**Application by Port of Tilbury London Limited for an Order Granting Development Consent for a Proposed Port Terminal at the Former Tilbury Power Station ("Tilbury2")**

**Highways England's representations for Deadline 6**

**Highways England: Outstanding issues**

## TRAFFIC REGULATION MEASURES PLAN

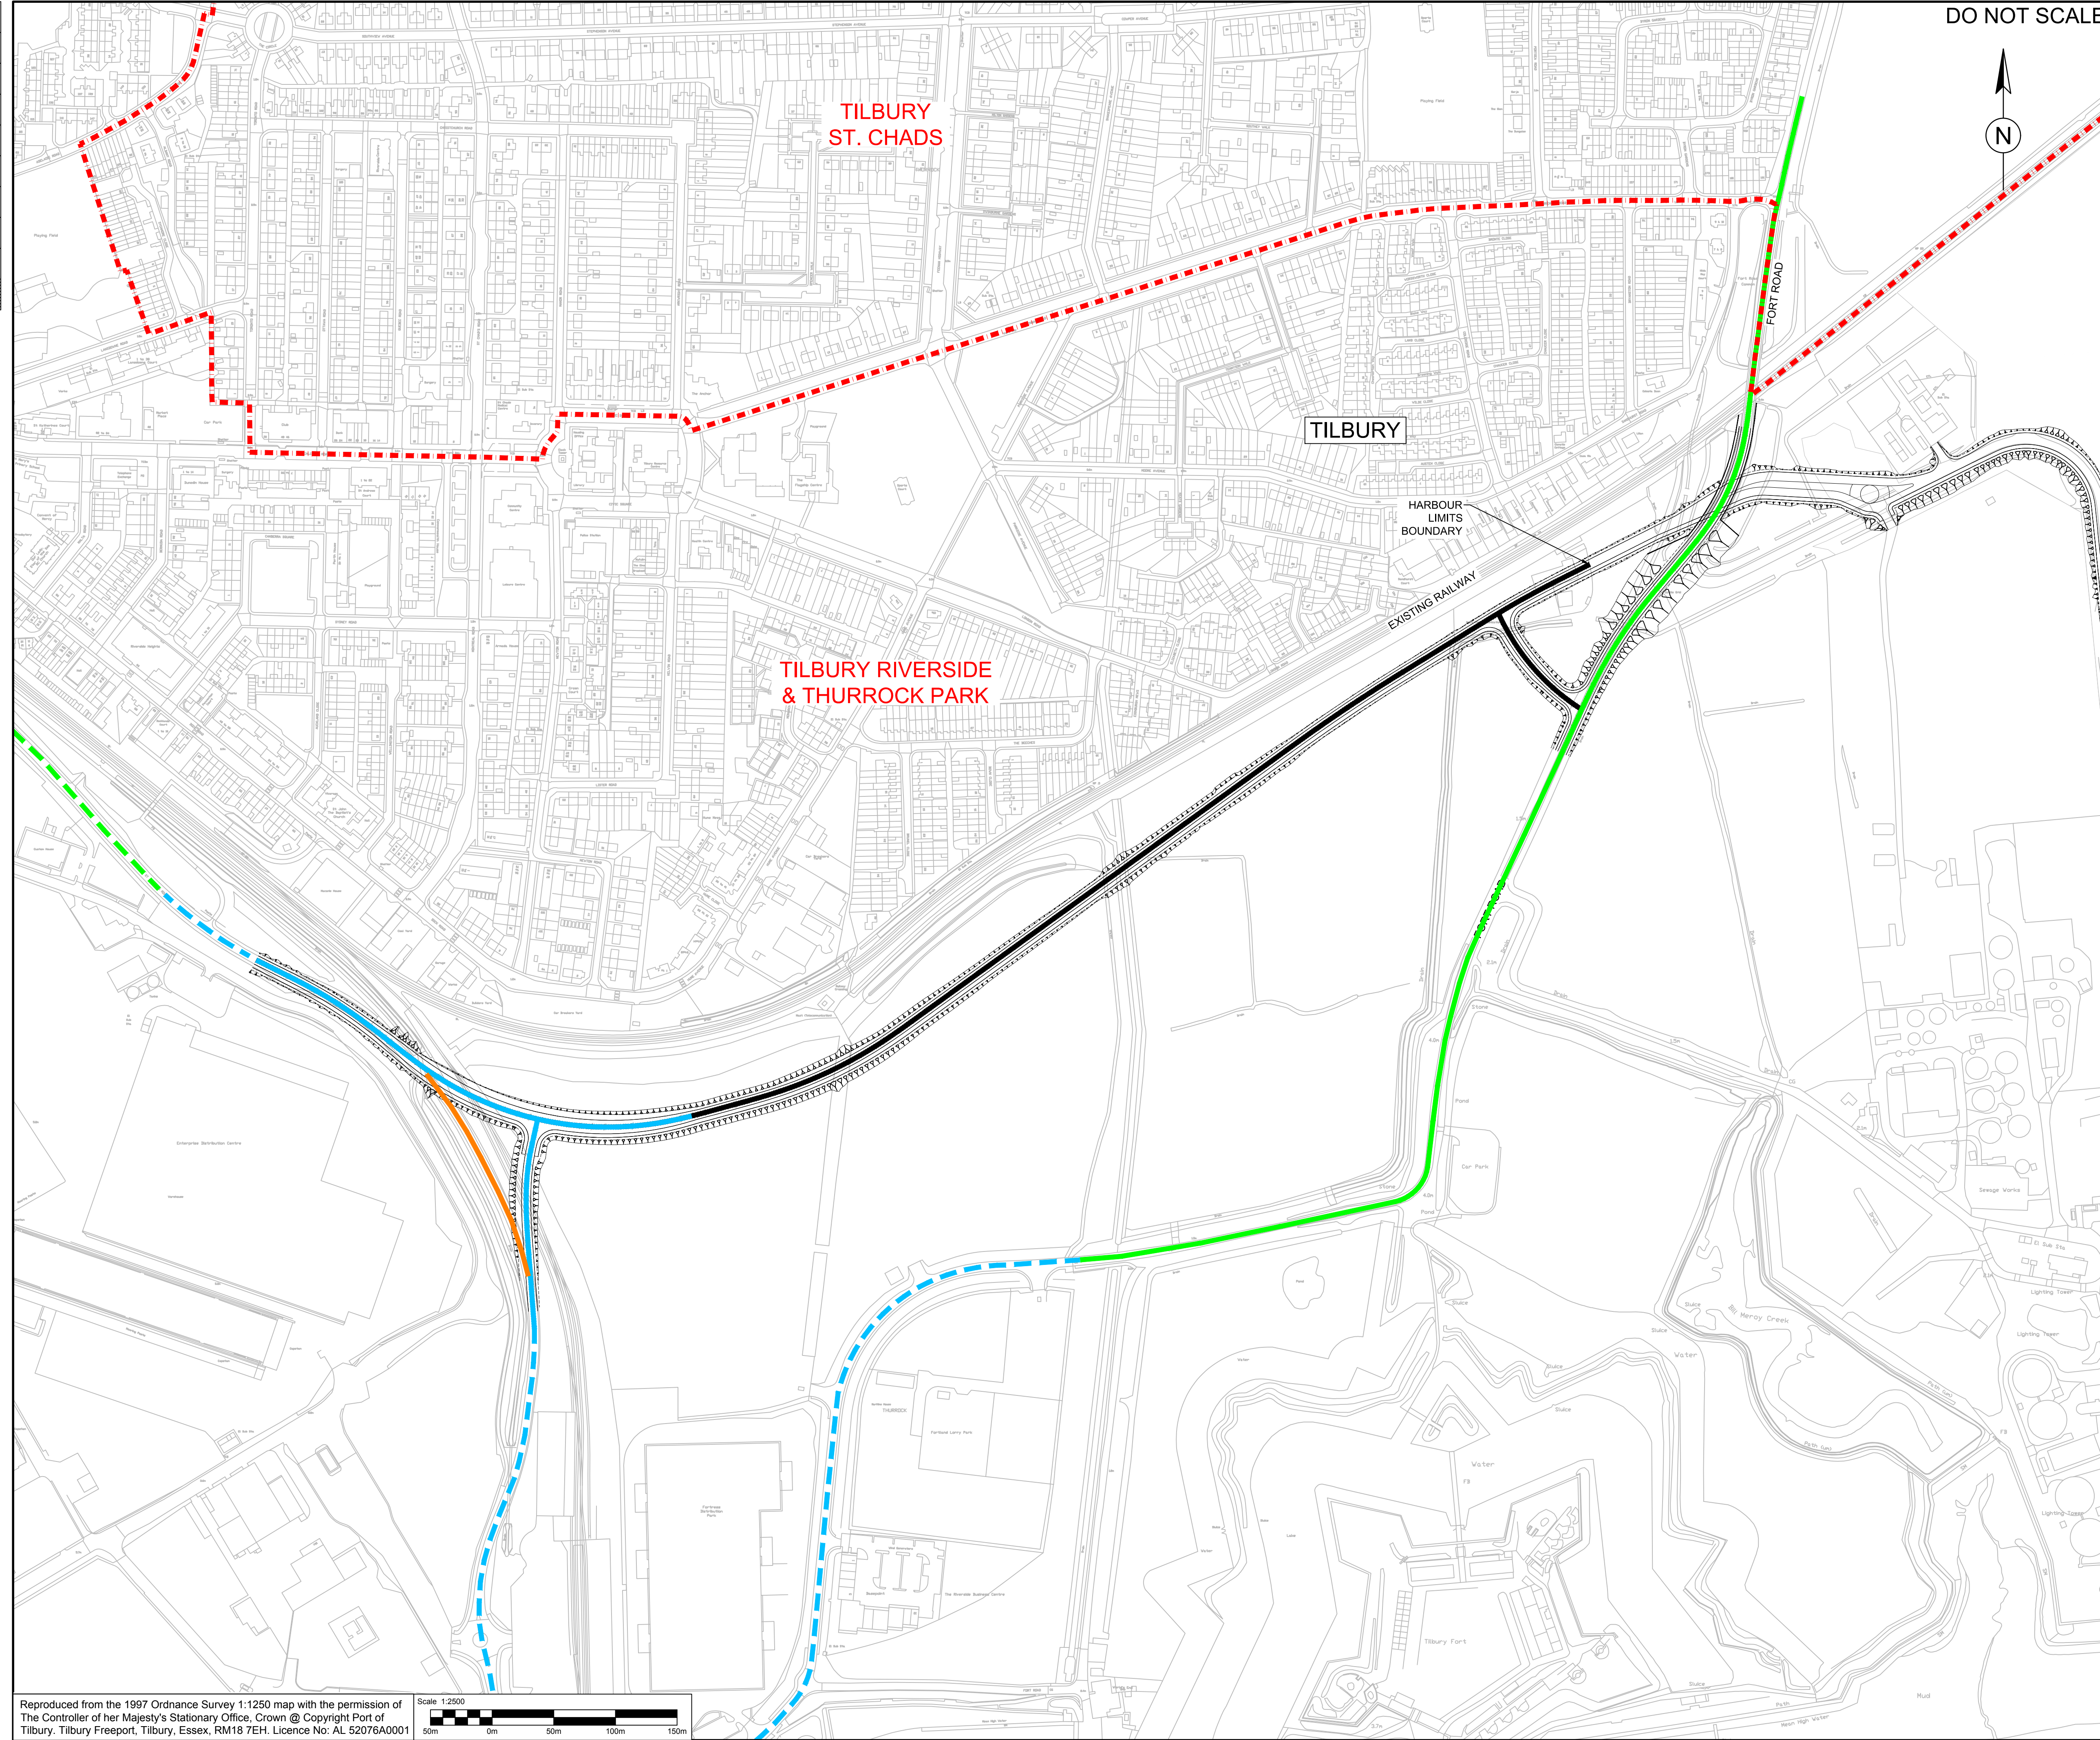
HE can confirm that it is cognisant of the details of more recent contact between the Applicant and Essex Police on the consideration of changes to speed limits at Asda Roundabout. We expect that an update will be provided by the Applicant as part of its response to Deadline 6. We are able to confirm HE's understanding of the position as follows:

Essex Police are content as to the proposed speed limit changes is as follows:

- There is no objection to the proposed 30mph speed limit on the ASDA roundabout circulatory and approach;
- There is no objection to the proposed 50mph speed limit on the A1089 between Marshfoot Road junction and the Asda Roundabout *subject to assurances that appropriate methods of enforcing the speed limit are provided in association with the proposed change.*

Accordingly, it is expected and it is understood that *the Applicant agrees that it must consult further with Essex Police on the details of the proposed changes alongside the other changes to Asda Roundabout and road network associated with the Port expansion, as part of any exercise of the above proposed powers.*

- the circulatory carriageway of the roundabout (and the immediate approaches) would become subject to a 30mph limit.
- The A1089 north of the roundabout to the Marshfoot junction would become subject to a 50mph limit. This will be introduced as a transition between the national (70mph) speed limit and the proposed 30mph on the roundabout.
- Improvements are at preliminary design stage and would be subject to further consultation as the design develops.

HE has agreed with the Applicant to liaise further with Essex Police at this time to gain clarification of the measures required to be secured as part of the dDCO. Depending upon their response, it is anticipated that a further change to the dDCO may be required to secure delivery of the enforcement measures that they outline and to make clear that are further consulted on the proposed speed limit changes at later detailed design stages in relation to the road network where the Applicant relies on the powers in Article 52(1) (as above). The same is required for HE in respect of the SRN.
